# Consultation Pre Lodgement Feedback Report

## **St Aloysius College Redevelopment SSD8669**

Prepared By  
**Urban Concepts**

In Conjunction With The  
**Craiglea Strata Committee**

ARTIST'S IMPRESSION OF UPPER PITT STREET ELEVATION

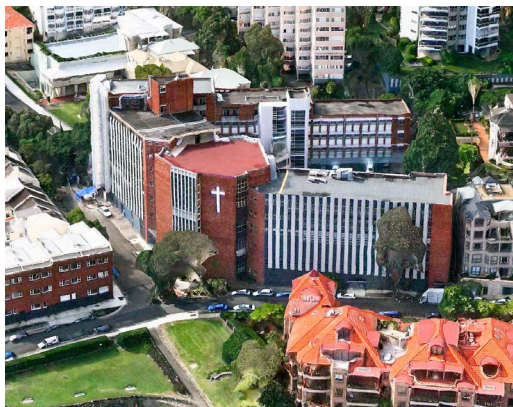
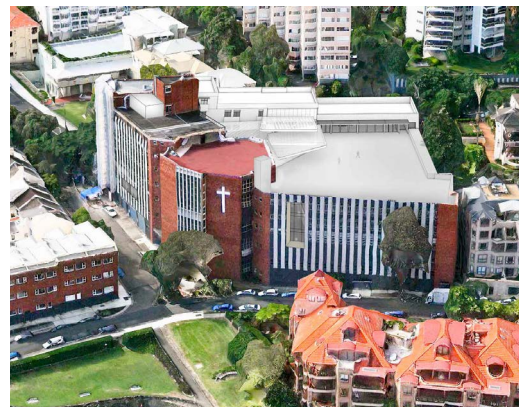
The Request for SEAR's does not address the heritage significance of Craiglea. The design response being advanced for the Middle Campus infills the quadrangle providing a minimum setback and an imposing vertical wall along the eastern boundary. This design response indicates that little consideration has been given to the heritage setting of Craiglea House and its garden curtilage.

Of particular concern is the failure of the proposal to achieve the 45 % site coverage. We can find no justification for a design scenario that looks to infill the centre quadrangle of the site without providing any built form or landscape relief on any other part of the site.

The limited setback that is provided along the eastern College site boundary is inadequate and will result in an imposing vertical wall that fails to respect the heritage significance of the Craiglea property and its garden curtilage. Further it will have significant and adverse amenity impacts for Craiglea residents with regard to overshadowing and solar access, viewsharing, acoustic and visual privacy.
